## Development Facilitation Team (DFT) – Review Comments

**DRB Project No: PR-2022-007645 Date: 03/22/2023 Agenda Item: #4 Zone Atlas Page: J-10**

**Legal Description: [LOT 2 TRACT S-1, UNIT 2, ATRISCO BUSINESS PARK]**

### Application For: SD-2023-00053-PRELIMINARY/FINAL PLAT (DHO)

**Plat for
Lots 2-A, 2-B, and 2-C, Tract S-1
Atrisco Business Park, Unit 2
Being Comprised of
Lot 2, Tract S-1,
Atrisco Business Park, Unit 2
City of Albuquerque
Bernalillo County, New Mexico
March 2022**

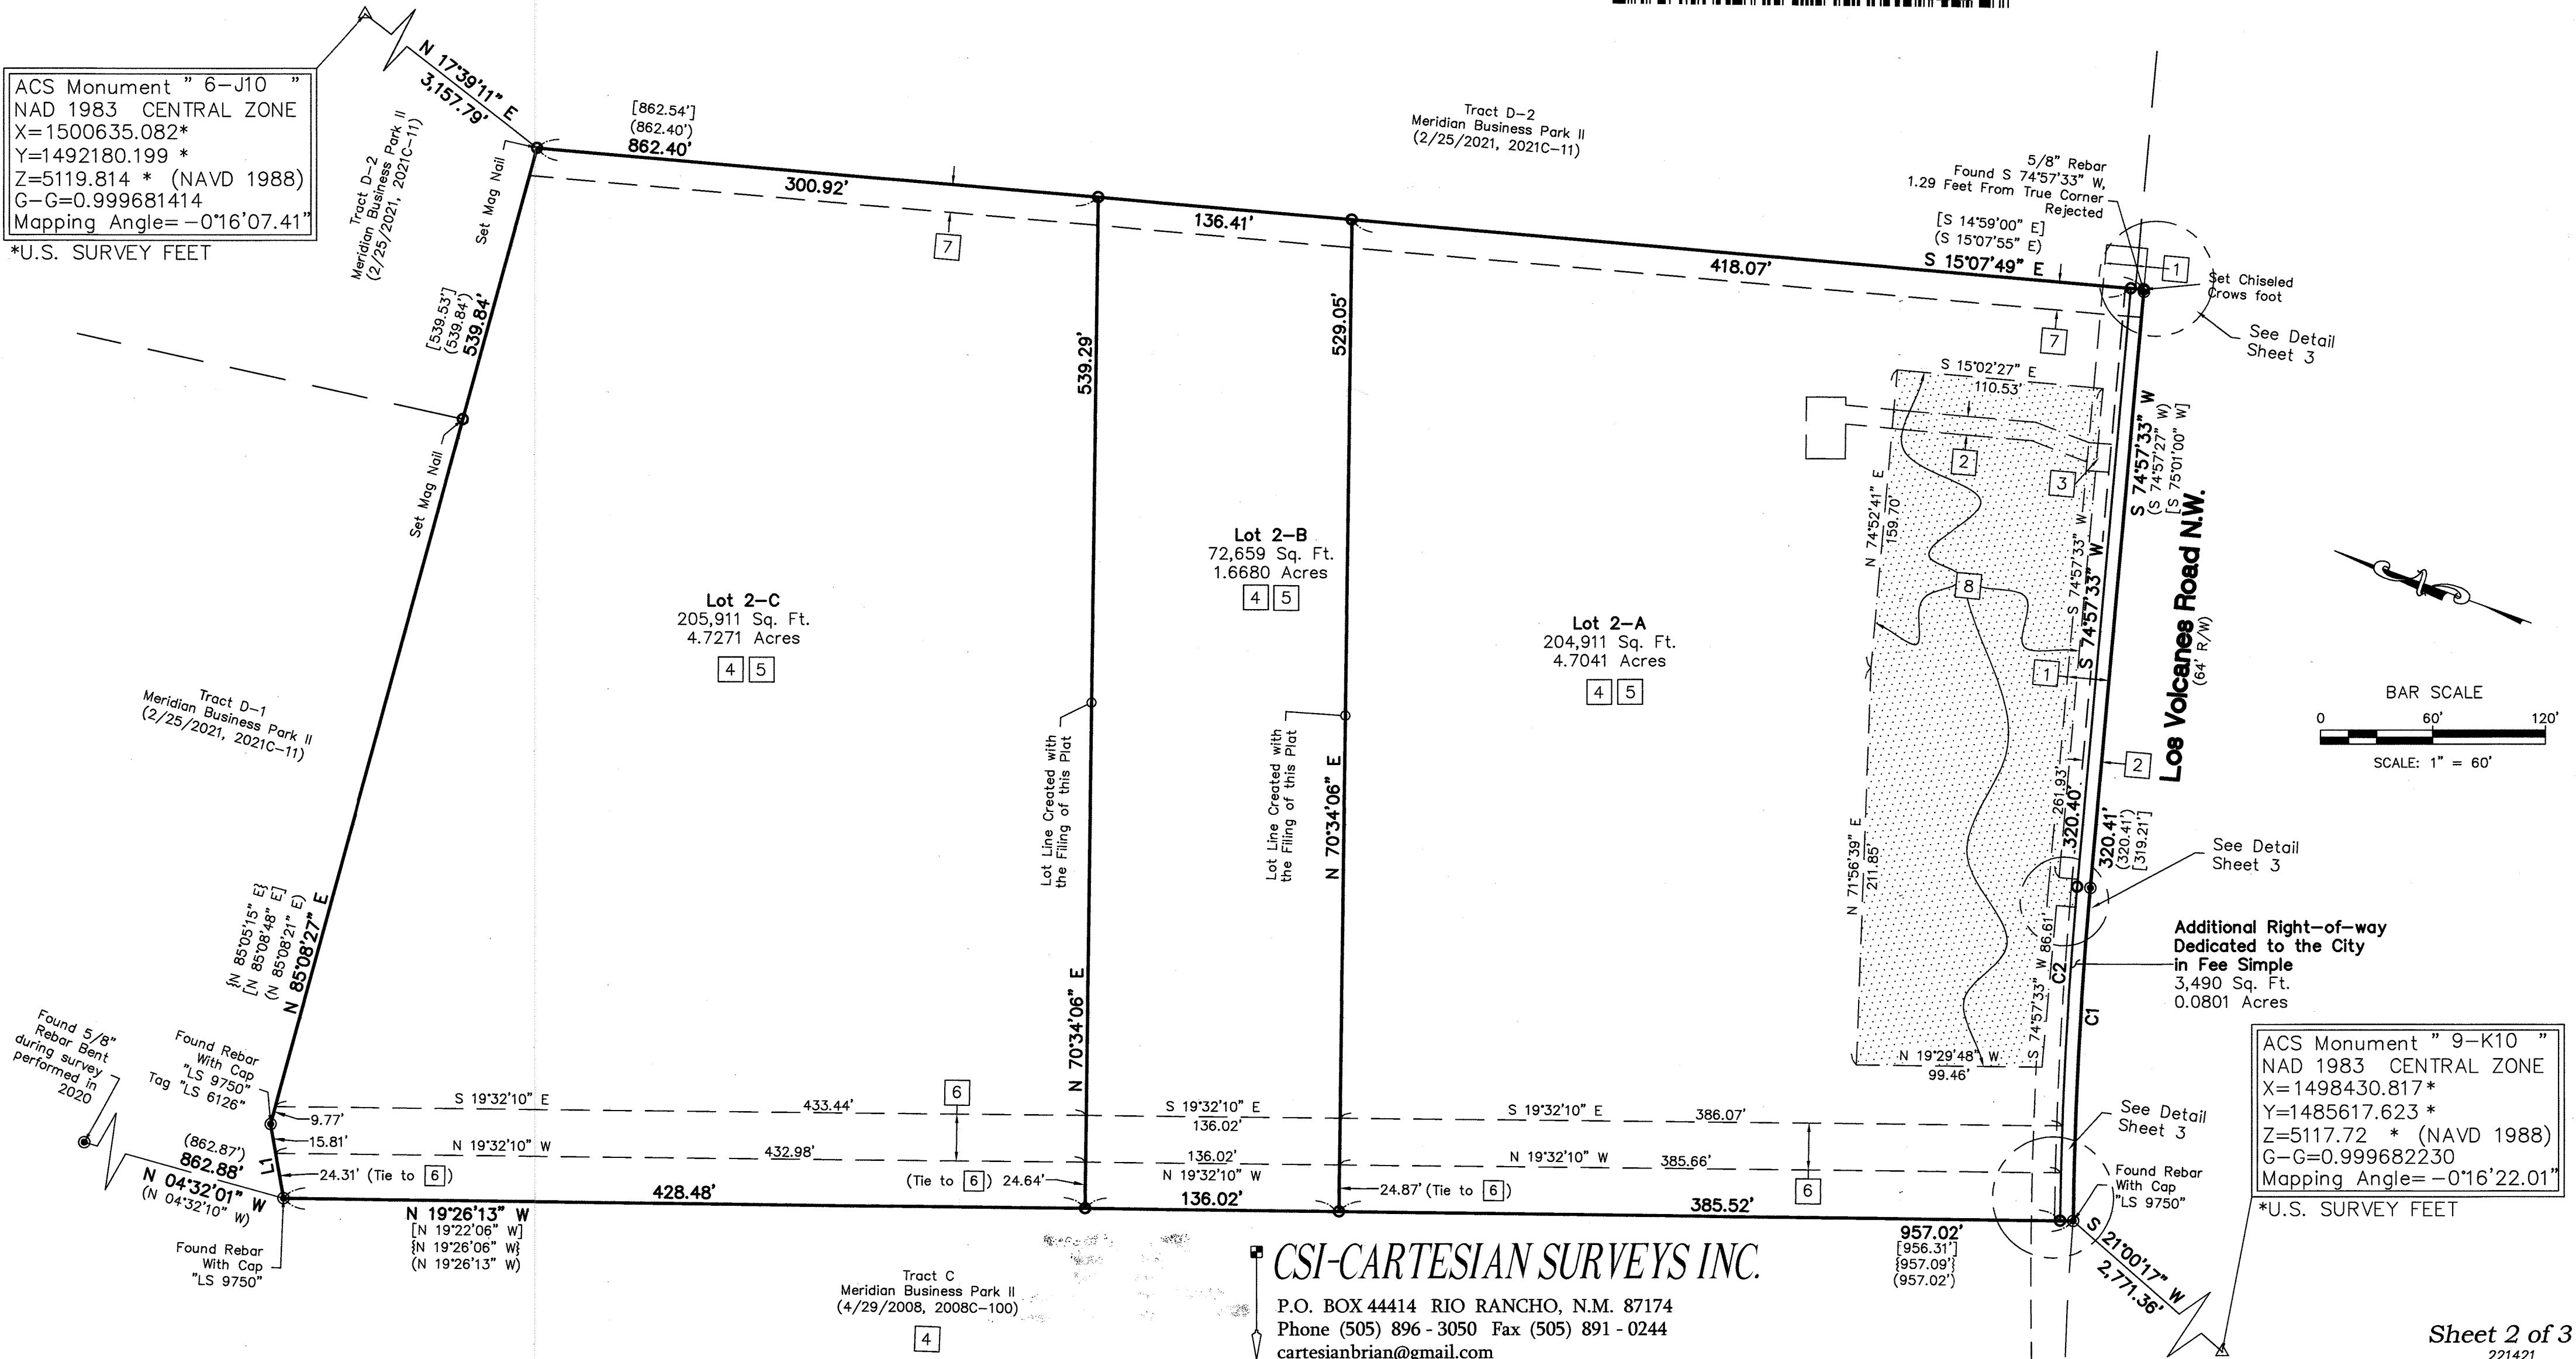
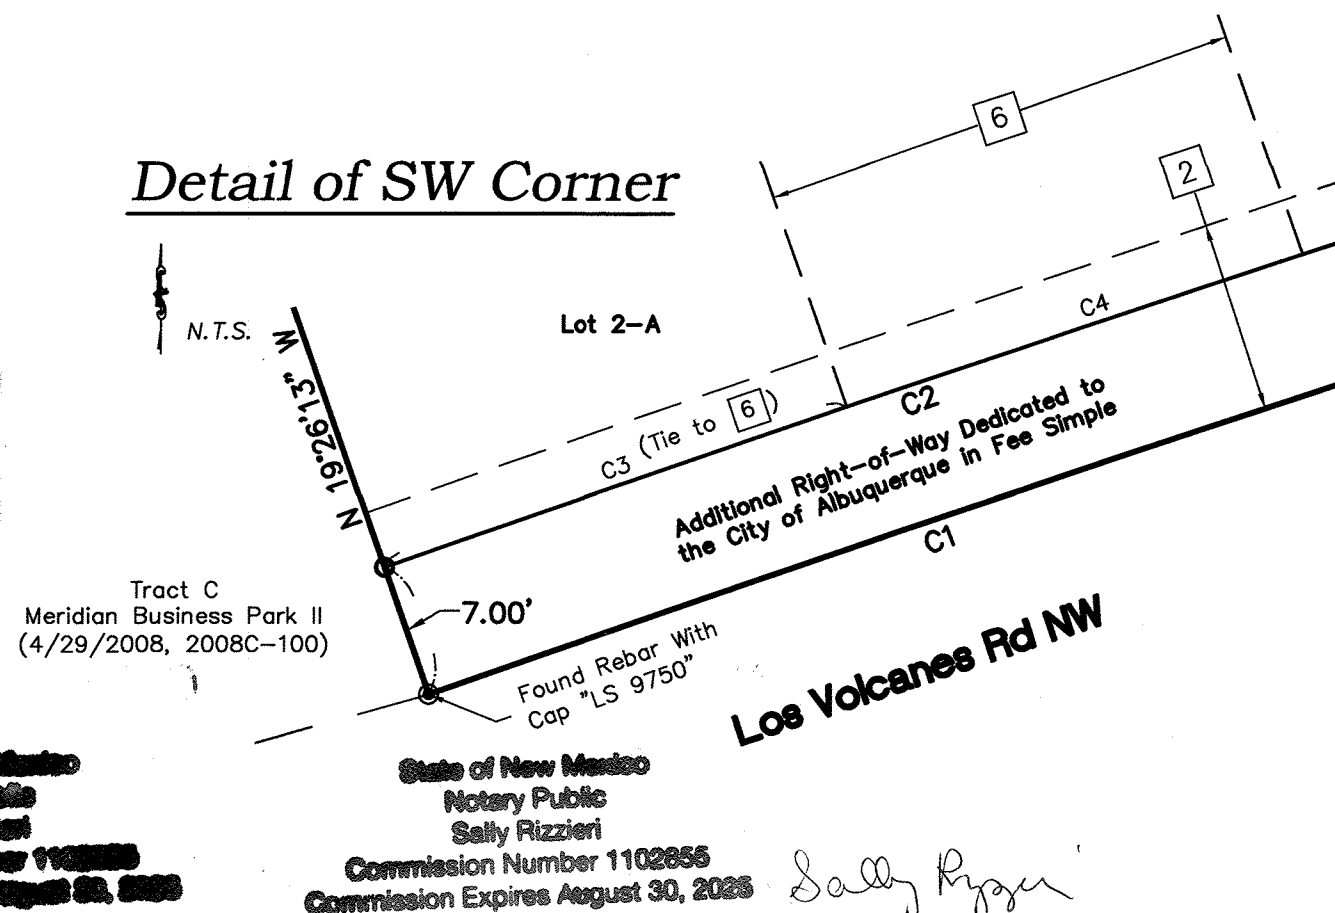
- a. A public water and public sanitary sewer extension is required and noted on the Infrastructure List.
2. Please ensure that the public water and public sanitary sewer infrastructure is not within a sideyard easement and is within a corridor acceptable to the Water Authority. The easement shall be aligned along an appropriate drive isle free of curb and gutter and the proposed infrastructure shall not be under parking spots or any landscaping.

- a. The easement may need to be relocated to the entrance
3. Provide a site utility plan showing the proposed infrastructure also labeling private vs. public infrastructure on the utility plan.

4. Please add the following note to the plat:  
**ABCWUA Public Water & Sanitary Sewer Easements**  
Albuquerque Bernalillo County Water Utility Authority (ABCWUA) is granted easement(s) in the dimensions noted on this plat for the construction, installation, maintenance, repair, modification, replacement and operation of public water and sanitary service lines, equipment and facilities reasonably necessary to provide service together with free access on and over the easement and the right to remove trees, shrubs, undergrowth and any other obstacles, modifications, or structures which interfere with use of the easement.

1. Existing sidewalk width along Los Volcanes is called out as 4'. 6' sidewalk is required in this area with a 4-foot ADA pathway around all obstructions within right-of-way. The response to comments stated there would be a justification letter to request this remain, but I could find no justification letter in the submittal. 4' is below minimum City required sidewalk width. Please provide the required 6' minimum sidewalk.
2. For any future development, a Traffic Circulation Layout will be required prior to Building Permit. Please ensure all lots meet parking requirements for the development currently on each proposed lot.

- Hydrology has an approved Conceptual Grading & Drainage Plan (J10D027) with engineer's stamp 02/21/2023.
- The existing detention pond needs to be in a private drainage easement with the drainage easement notes showing maintenance responsibility for all three lots.

- Please clarify compliance of section 7 of the DPM, Table 7.2.29, regarding sidewalk width and landscape buffer.  
Los Volcanes is a Major Collector (not in a Center). Please detail existing sidewalk and landscape buffer widths.  
The table requirements are for a 6-foot sidewalk and a 5-6 foot landscape buffer.  
A justification letter regarding maintain existing widths that meet ADA could be provided with the application, and the DHO would made a determination on maintaining existing widths. Any determination that is approved needs to be added as a note on the Plat.
